**ADC Planning Consultation
Conservation/Design Officer Response**

Application Number	LU/176/17/HH
Address	3A Norfolk Road Littlehampton
Description	Replacement windows to the upper floor of a building in a designated area
Case Officer	Anita Gardner
Date	12 July 2017

FRONT ELEVATION
East

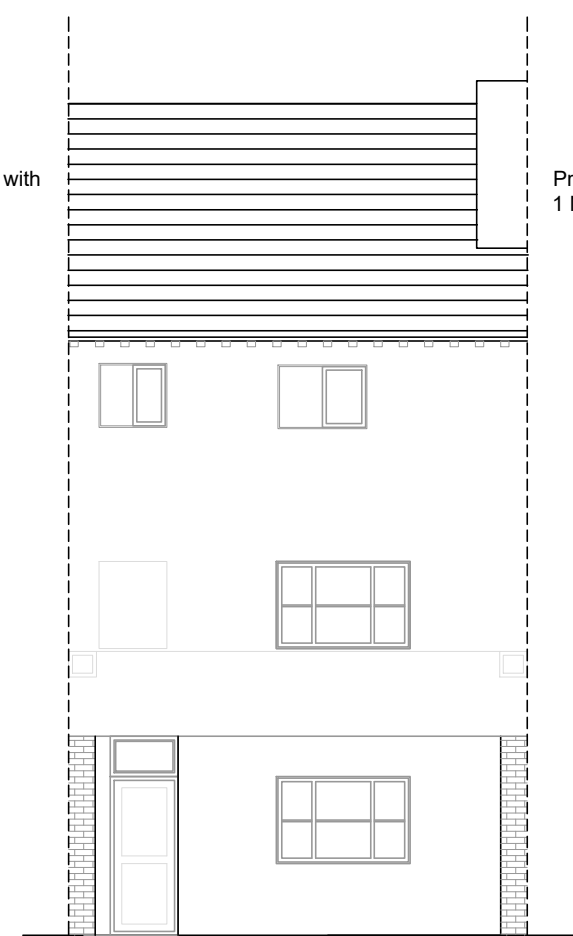
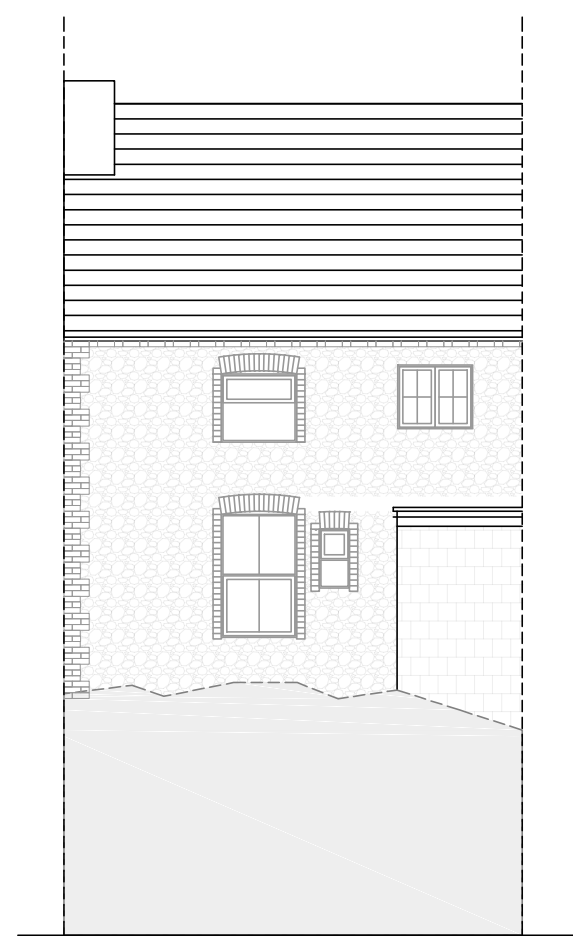
Fenestration is a defining feature of a building and within a designated area, the use of UPVC is strongly resisted, as it is a modern 'anywhere' material, devoid of local character and inappropriate to the local context. In order to preserve the appearance of the host building - and maintain its contribution to the special qualities of the designated area - replacement frames in highly visible elevations must be of comparable materials and similar appearance to the original windows, and thus reasonably consistent with the initial architectural intention. However, modern alternatives such as UPVC may be condoned for rear elevations which are barely visible from the public realm.

Poor precedents in neighbouring buildings do not justify further unsympathetic work, as the cumulative effect of inappropriate windows erodes the locally distinctive qualities of a designated area and harms its significance. Para. 132 of the NPPF requires great weight to be given to the conservation of designated heritage assets and refusal for the installation of UPVC framed windows to the front elevation is recommended in terms of Local Plan 2003 Policy Area 2 and Local Plan 2014 Policy HER DM3.
